Response to Submissions

- Seating Areas
- Shelter
- Nodes
- Signage Opportunity

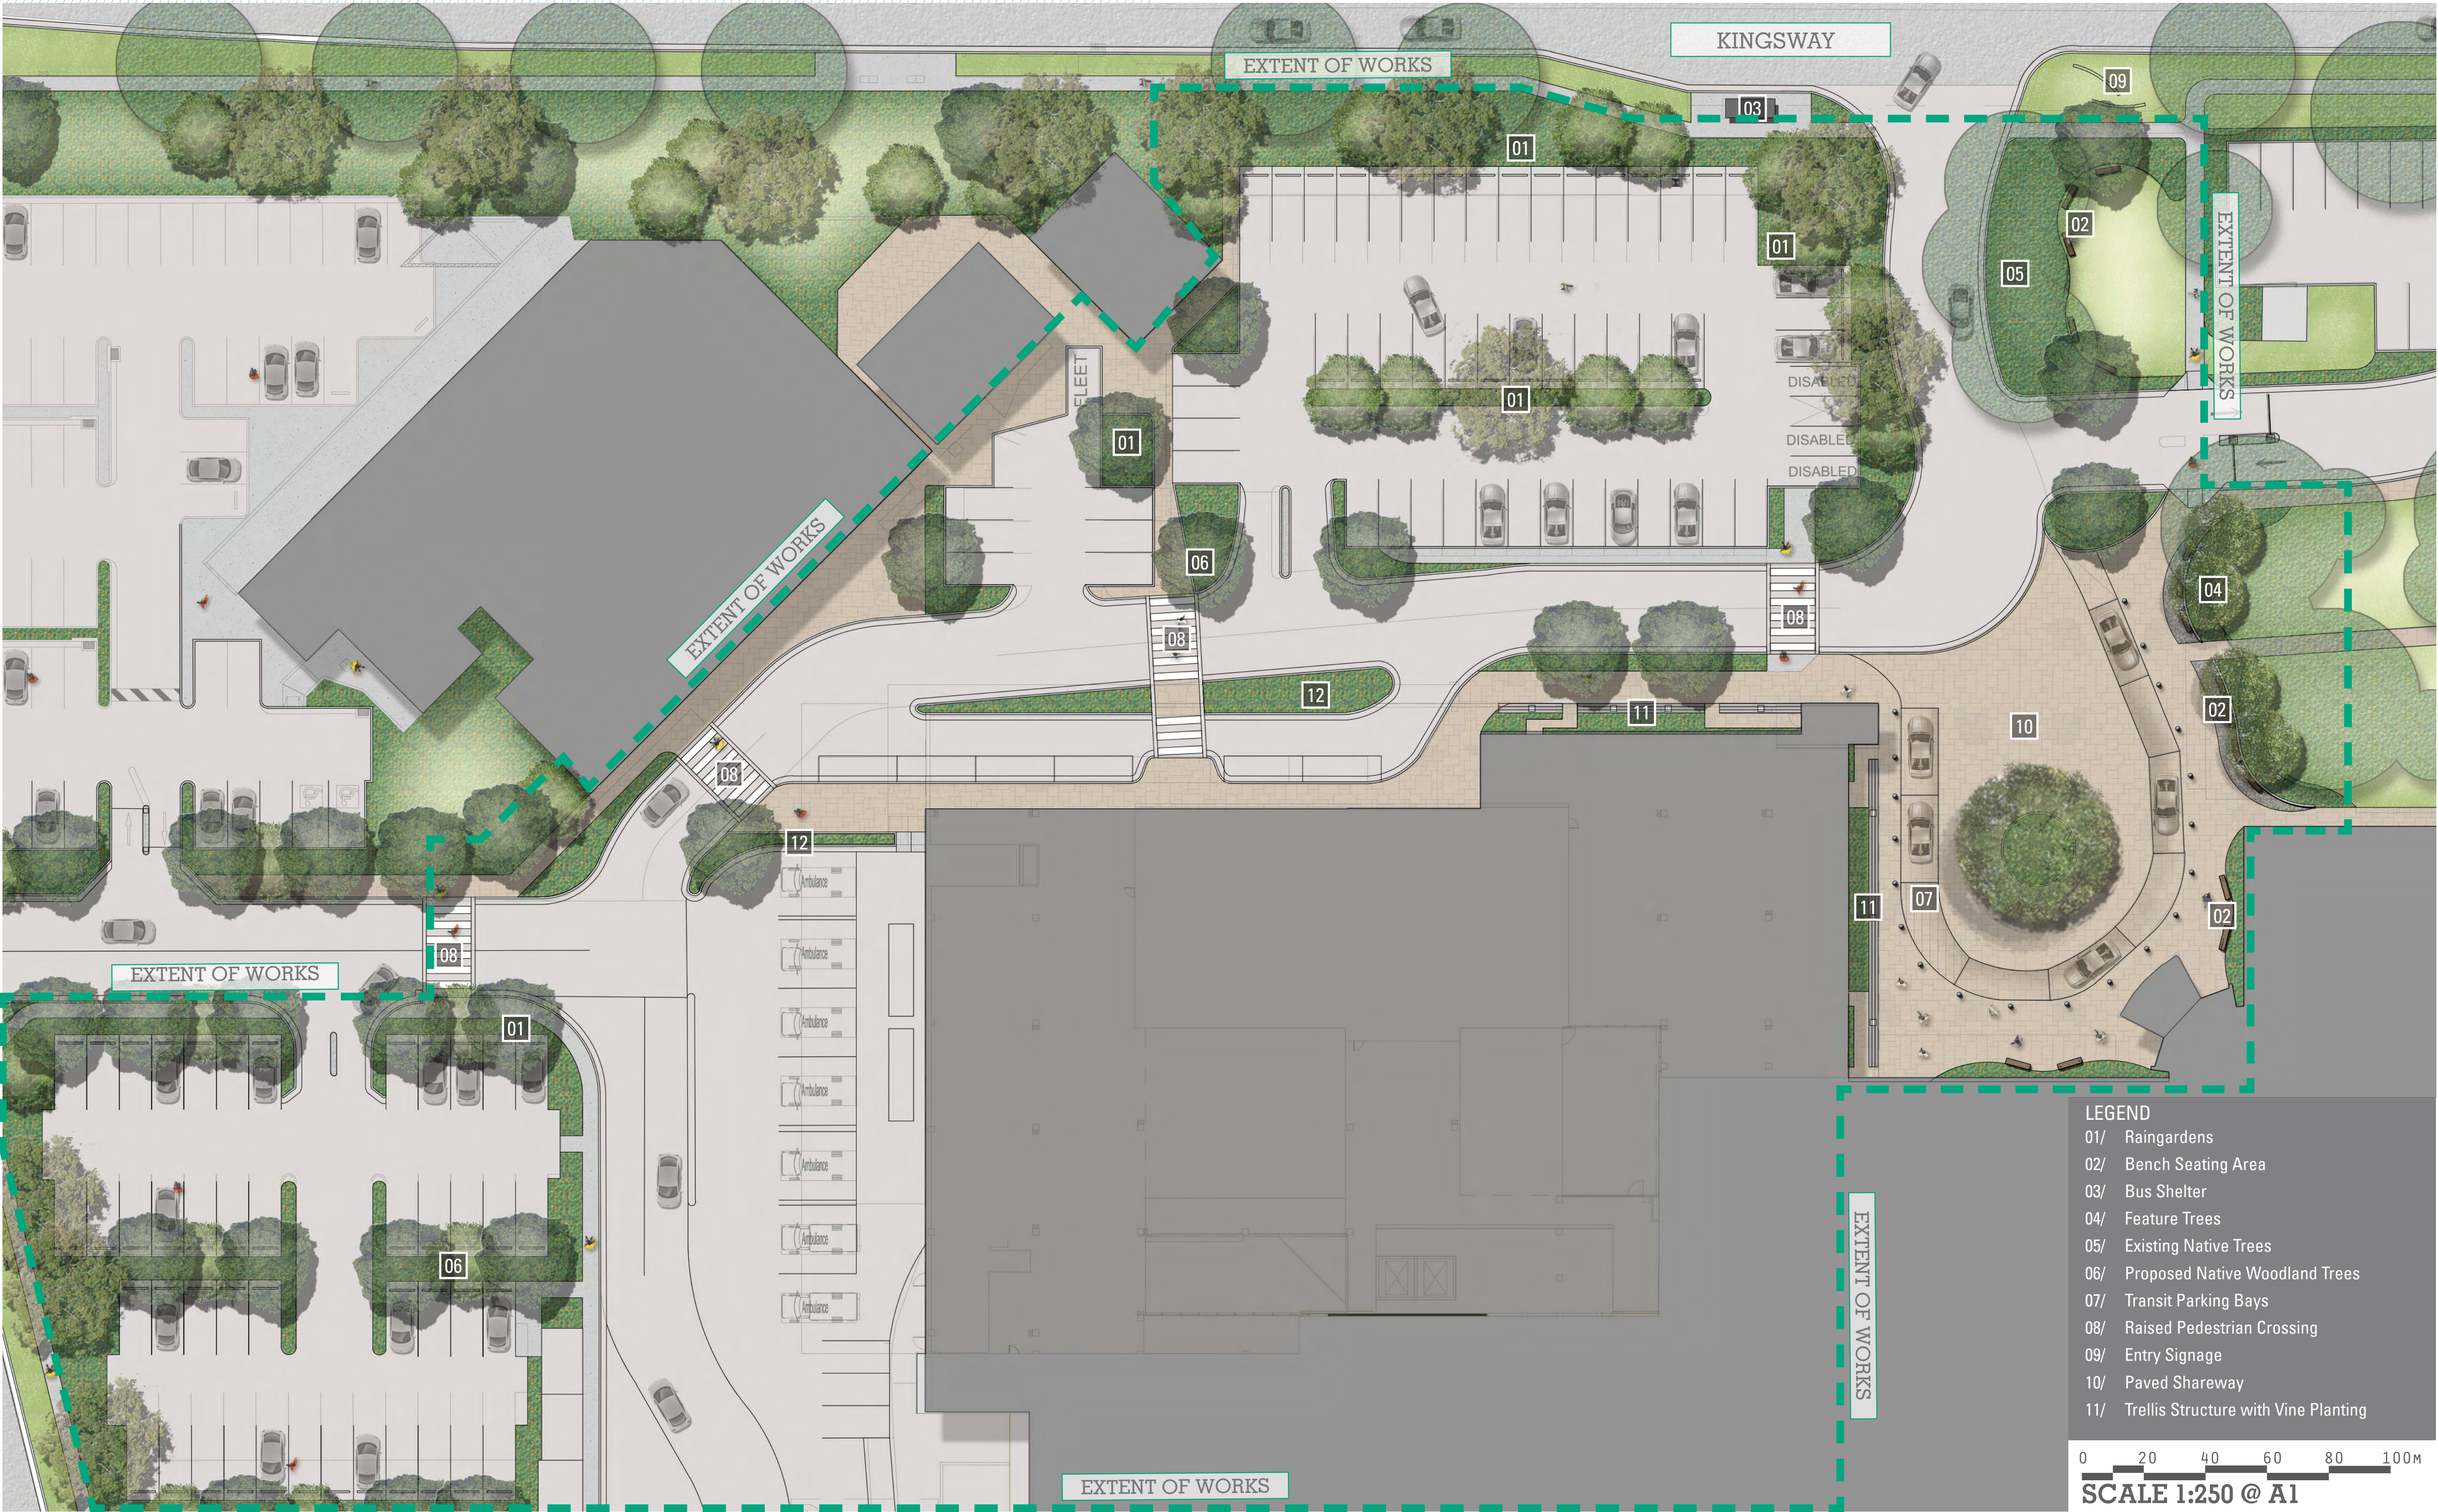
SSC	<p>Landscaping - SCC requests that indigenous tree planting be continued along the eastern section of the Kingsway between the</p>	<p>Amended landscape plans have been prepared by Arcadia to address this issue – refer Attachment 4.</p>
